City of Albuquerque Stormwater Construction Site Inspection Report

ESC File No.	B18E028	Project Name:	Burger King		
NPDES Id. No.	NMR100463	Location:	2110 Carlisle Blvd. NE		
2/28/2022	Owner	Contractor			
Operator	Auto Nation USA	Rycon Construction Inc			
Contact name & title	Fred Moss	Michael Burns			
e-mail	mossf@autonation.com	mburns@ryconinc.com			
Contact Phone #	954-769-2303	263-6965			
COA Inspector	Doug Hughes	Start/End Time:	4pm		
Construction Phase:	Excavation/grading				
Type of Inspection:	<input checked="" type="checkbox"/> Regular	<input type="checkbox"/> Storm Event	<input type="checkbox"/> Past Storm Event >0.25"	<input type="checkbox"/> 311/Complaint	<input type="checkbox"/> Follow Up
Weather at time of inspection?		clear		Temperature: ~	60
Estimated date of last storm 0.25" or greater		2/2/2022

SWPPP POSTING REQUIREMENTS:

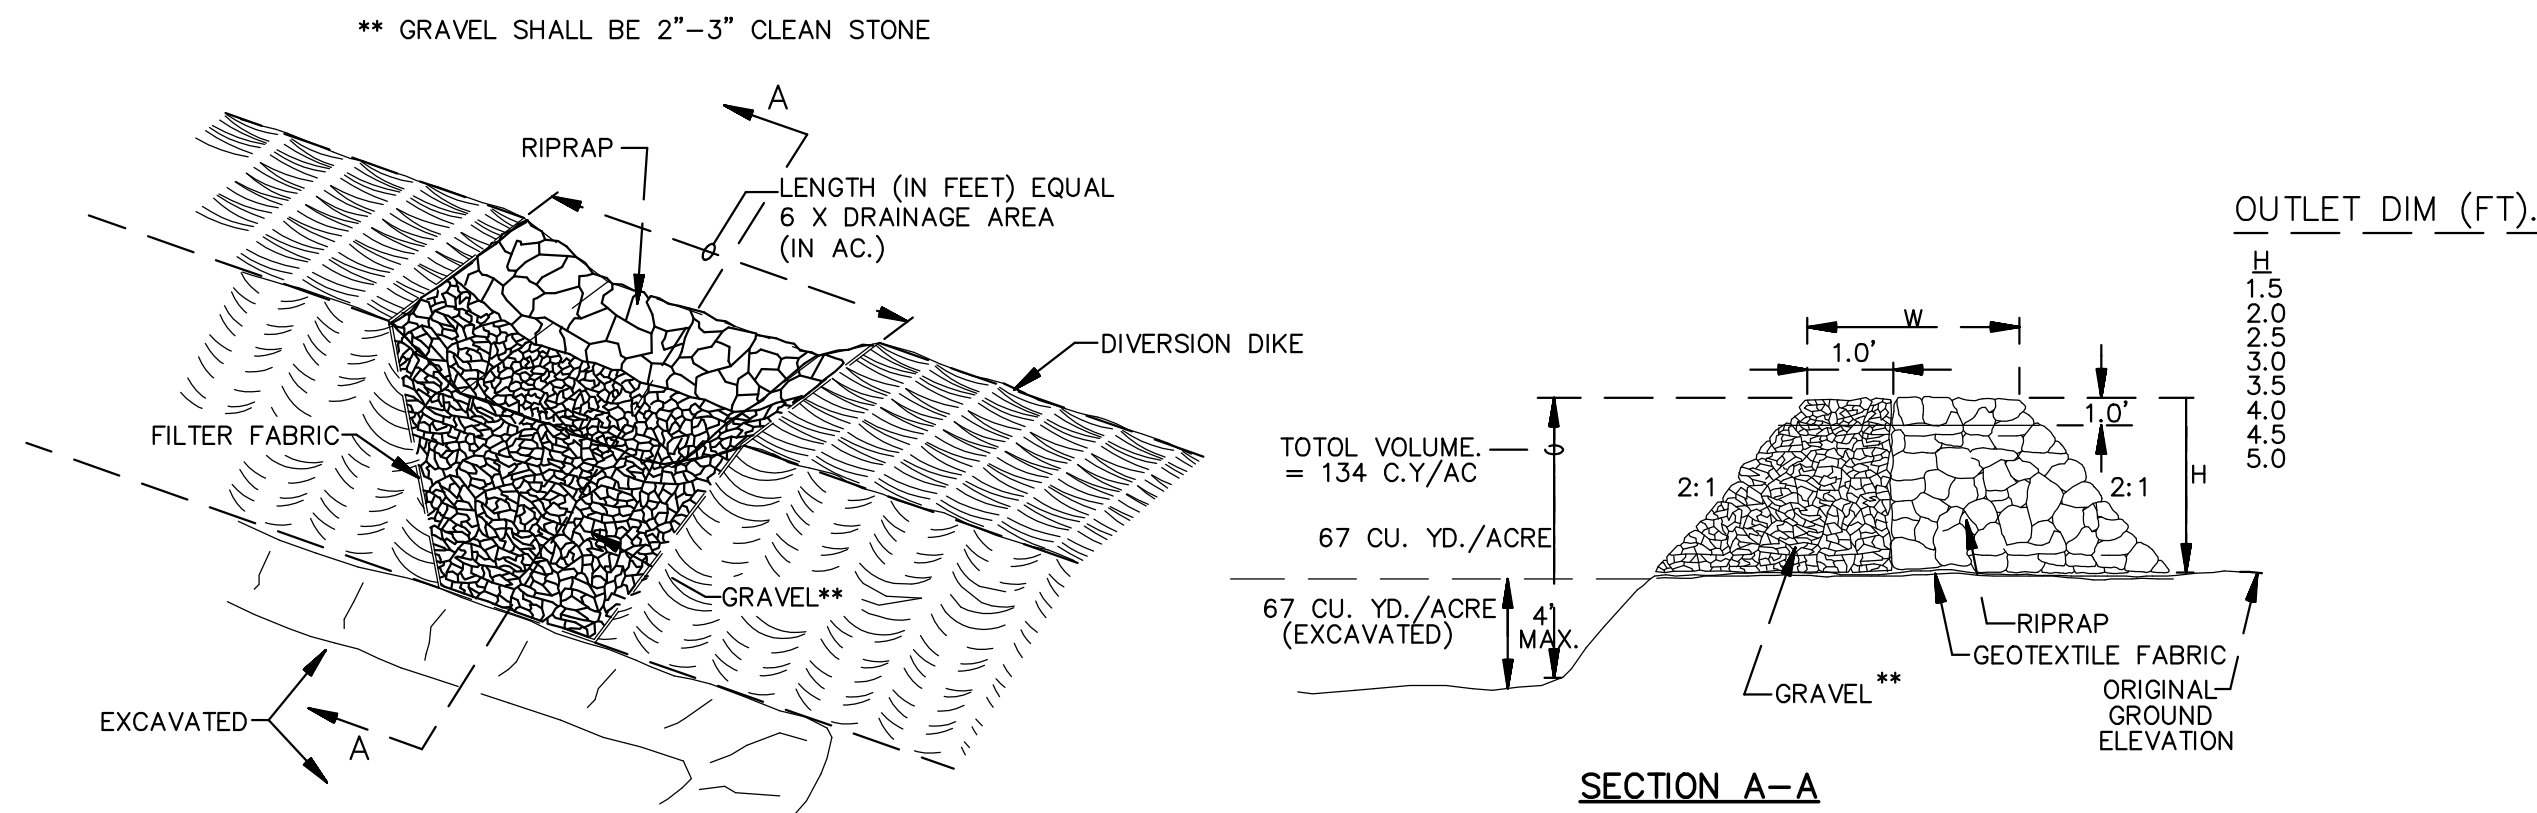
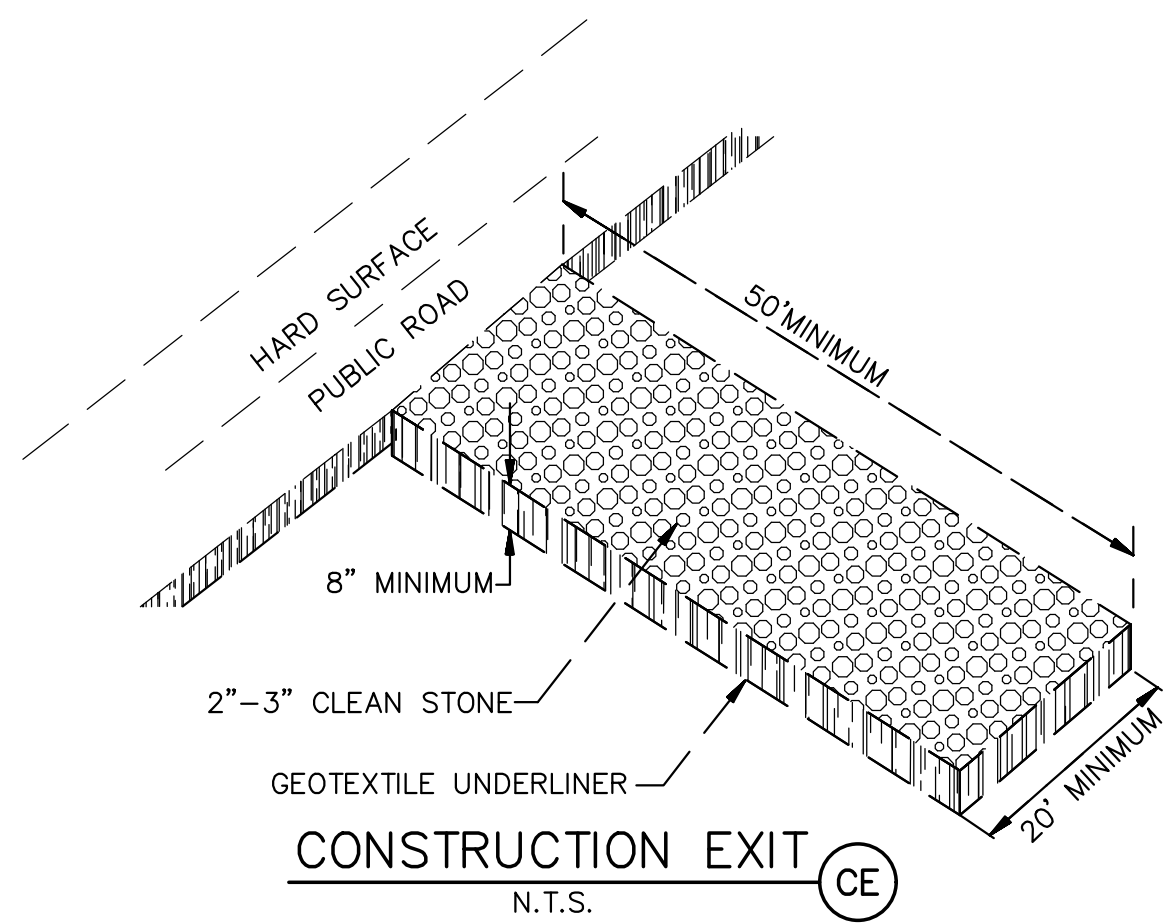
Notes:	
Foundation footings excavated and steel in the trench, but no washout container on site.	
The area of land disturbing activities has been increased to include the two lots adjacent to San Pedro, so the SWPPP map and NOI need to be revised, to update the SWPPP.
